WEST SUSSEX COUNTY COUNCIL CONSULTATION

TO:	Arun District Council FAO: Andrew Wood
FROM:	WSCC - Highways Authority
DATE:	25 March 2019
LOCATION:	3 The Hard, Elmer, Bognor Regis, PO22 6JS
SUBJECT:	M/24/19/PL Replacement residential dwelling.
DATE OF SITE VISIT:	N/A
RECOMMENDATION:	Advice
S106 CONTRIBUTION TOTAL:	£N/A

REV.	DESCRIPTION	DATE
1	PROJECT REPLACEMENT DWELLING 3 THE HARD ELMER SANDS WEST SUSSEX	
2	CLIENT Ms D HUANG	
3	DRAWING TITLE PROPOSED PLANS, ELEVATIONS & SITE PLAN - DRAFT ISSUE ONLY	
4	SCALE VARIOUS @ A1	DRAWN BY MUM
5	DATE JAN 19	
6	DWG NO PLO1	REV. /

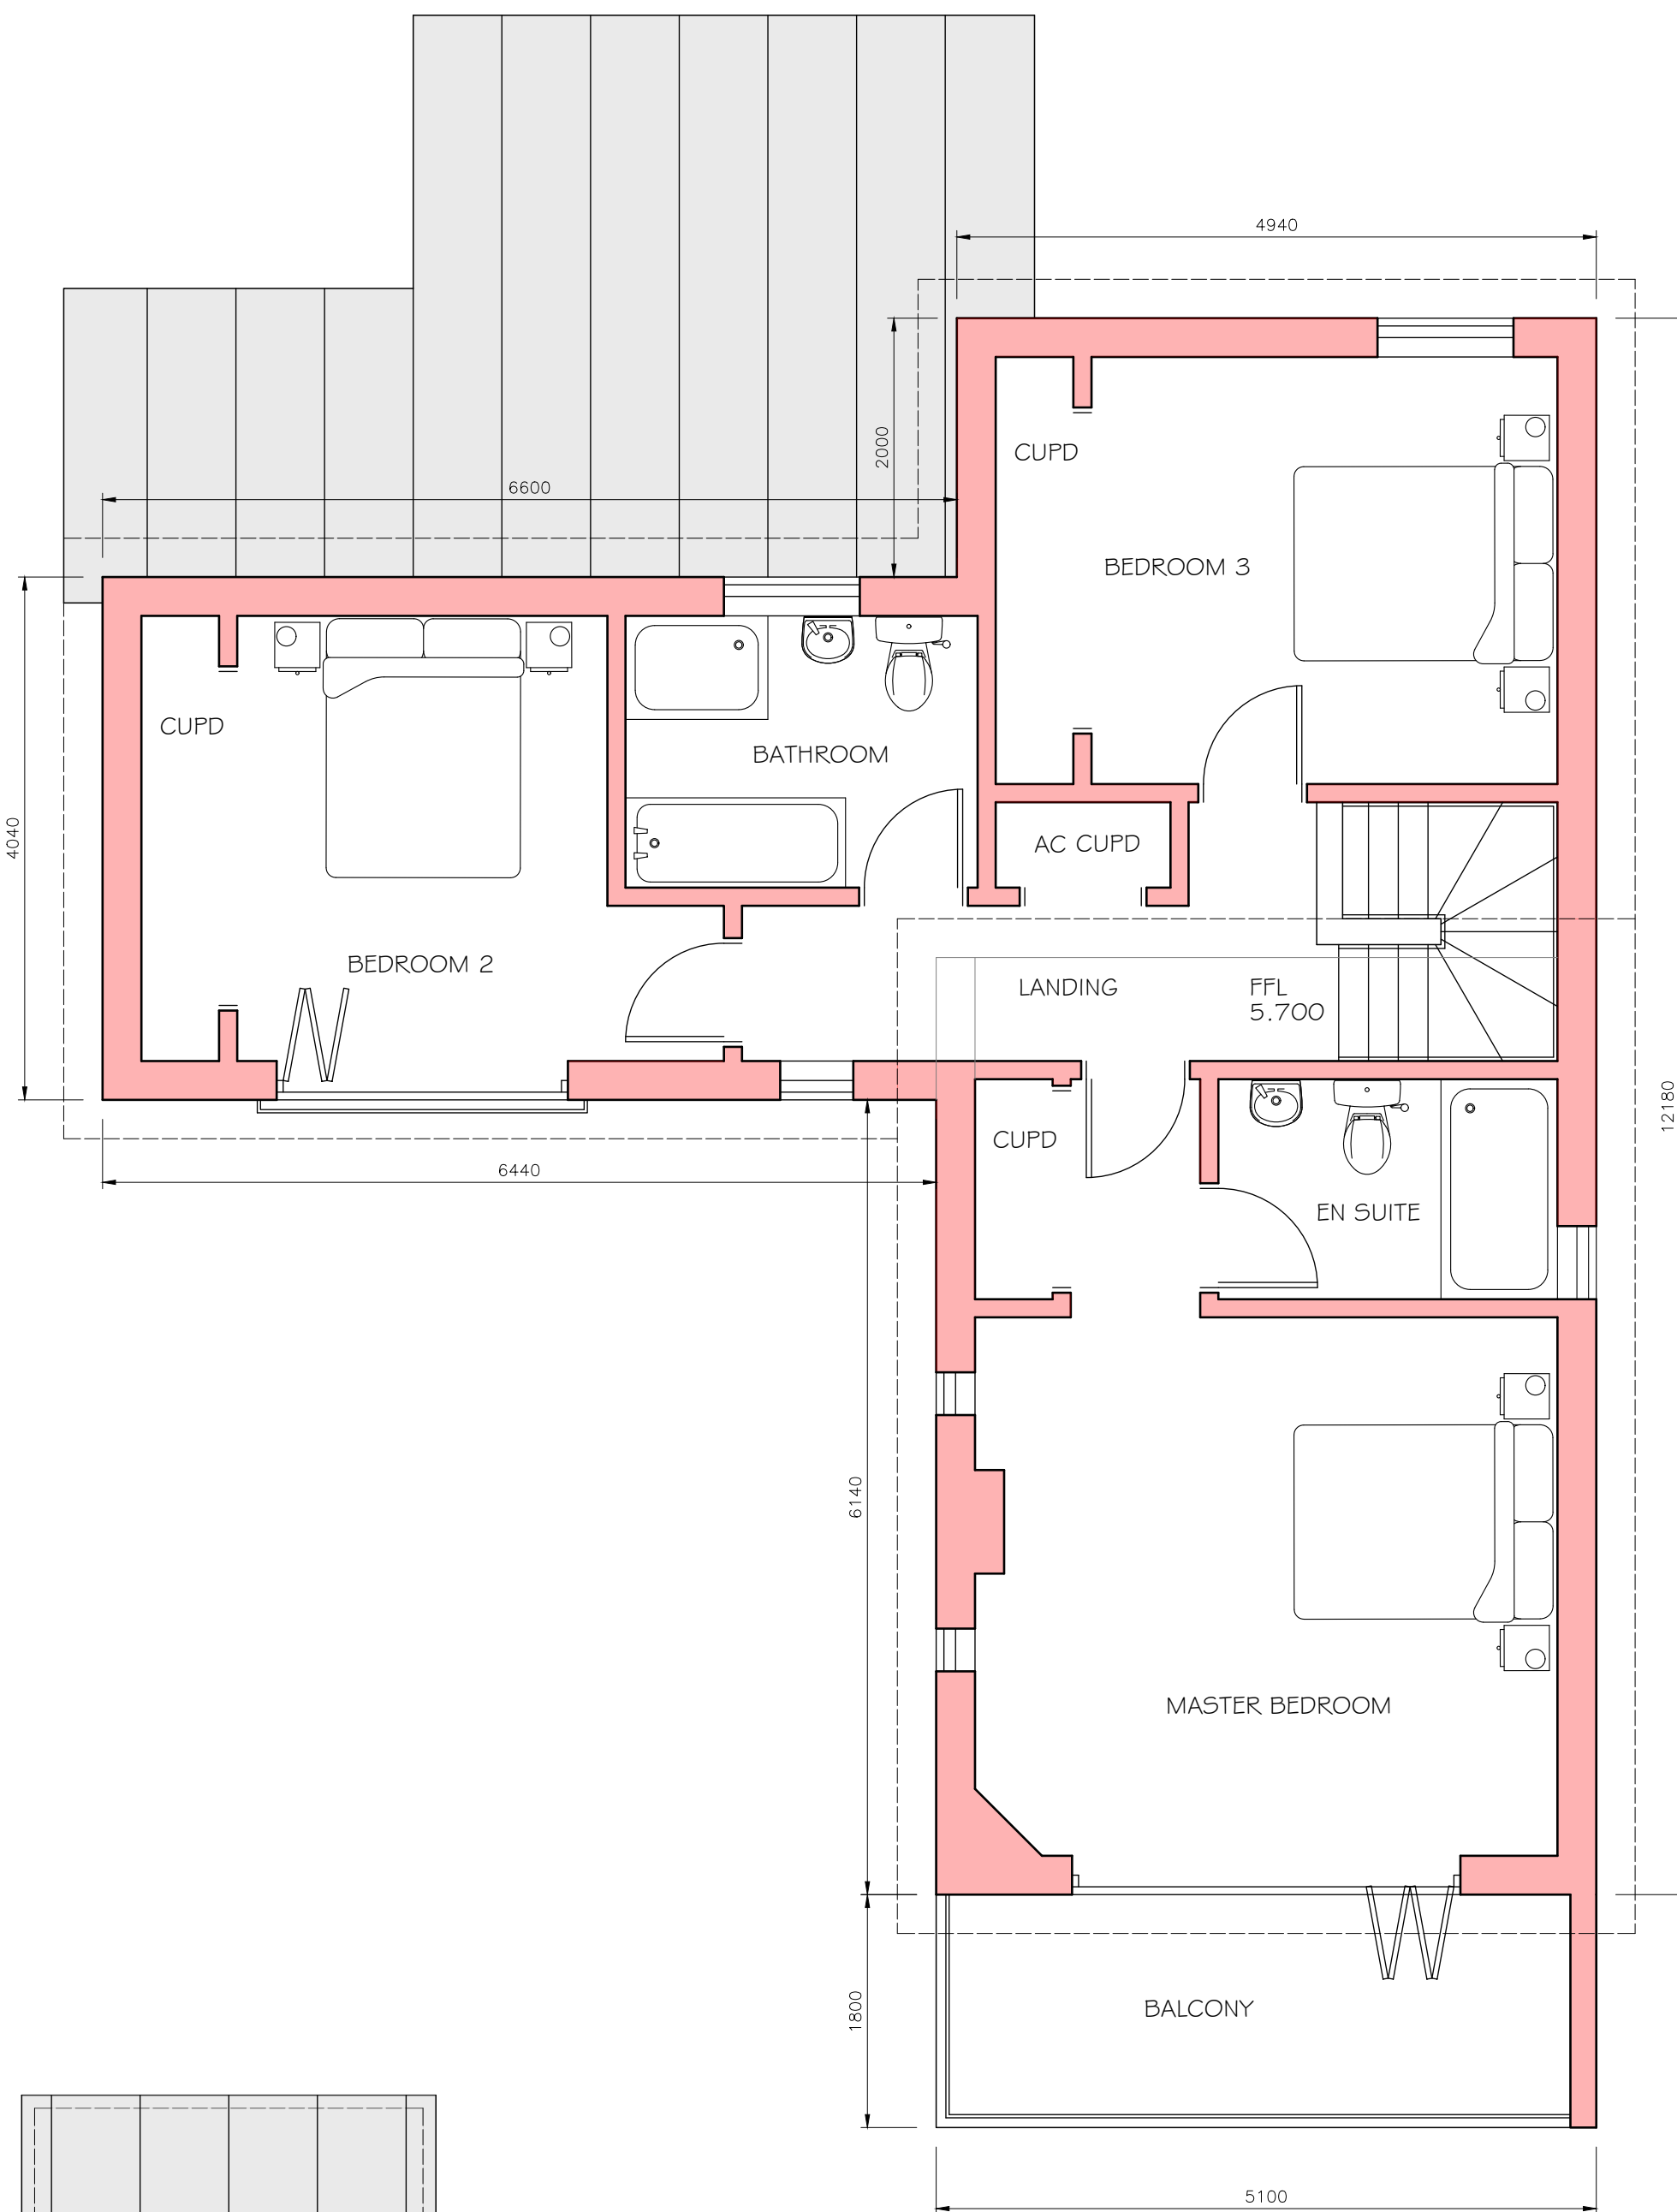
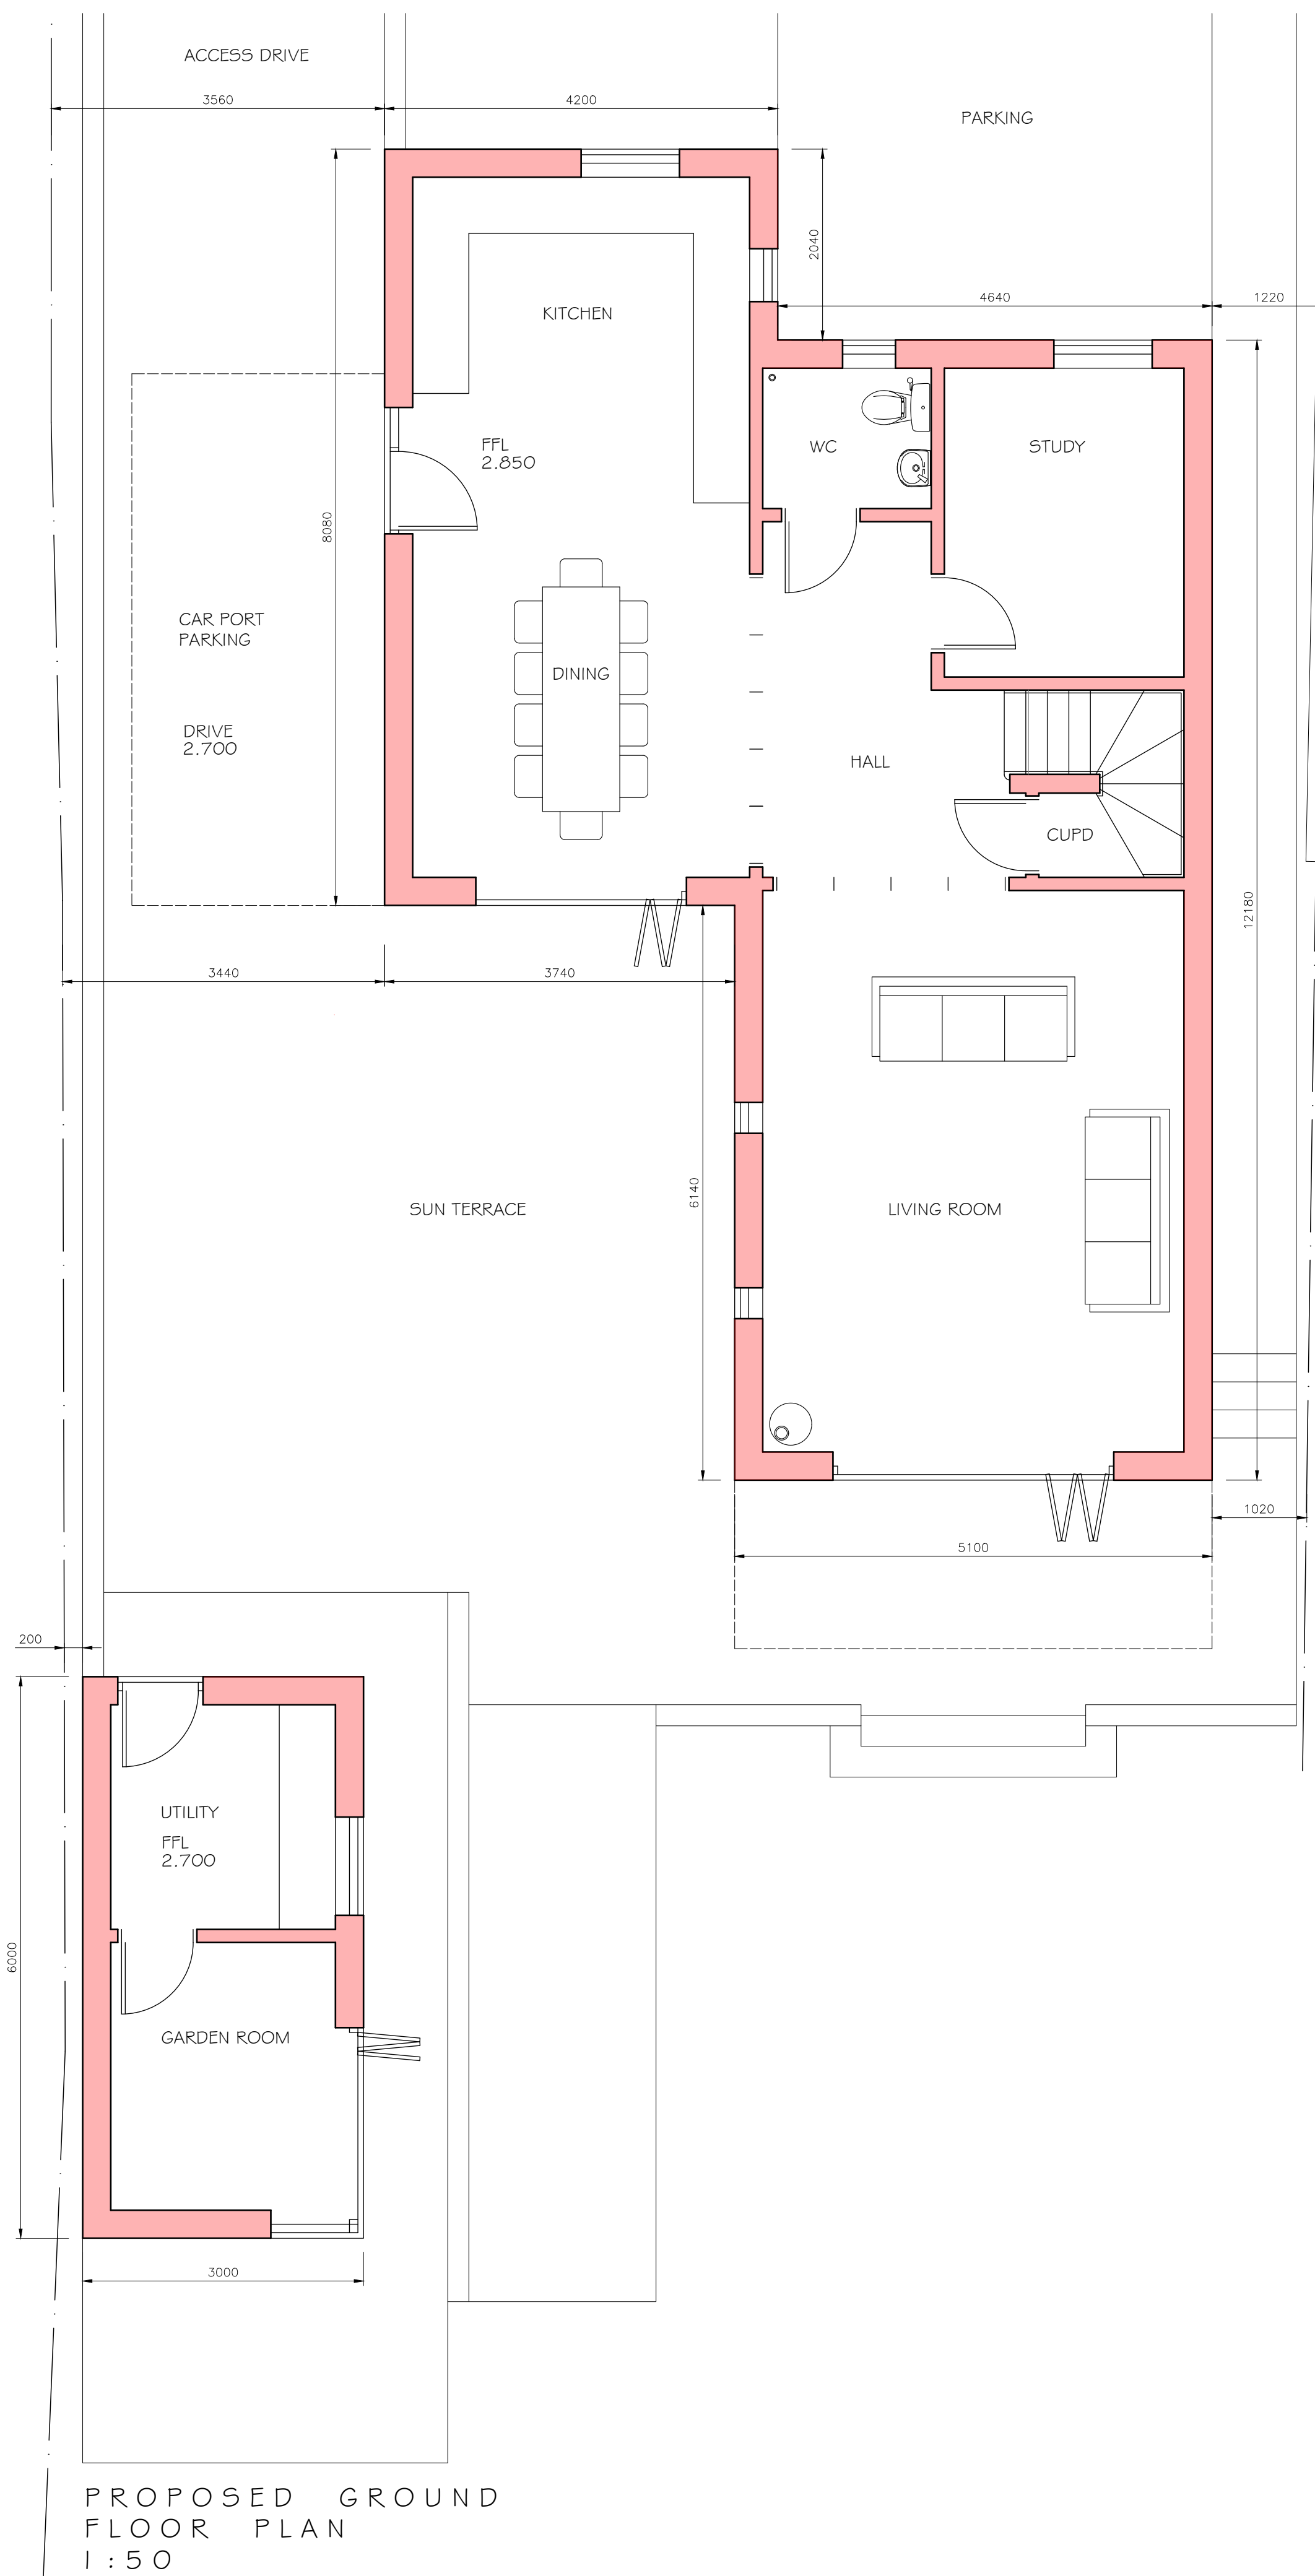
The site is located on The Hard, a privately maintained road subject to a speed limit of 20 mph. The driveway to the west is an existing access, and a second access to the north is planned to allow for 2 more cars to park.

3 car parking spaces are proposed for the replacement dwelling, one more than the existing property. The WSCC Car Parking Demand Calculator indicated the the proposed dwelling would create a demand for 3 car parking spaces. Therefore the proposed number of spaces sufficiently meets the demand. Turning on-site is not achievable, so vehicles entering of exiting the site would have to do so in a reverse gear.

Cycling is a viable mode of transport in the area and a suitable alternative to the use of private car. Cycle storage should be demonstrated in the plans to improve sustainability and allow an alternative transport options.
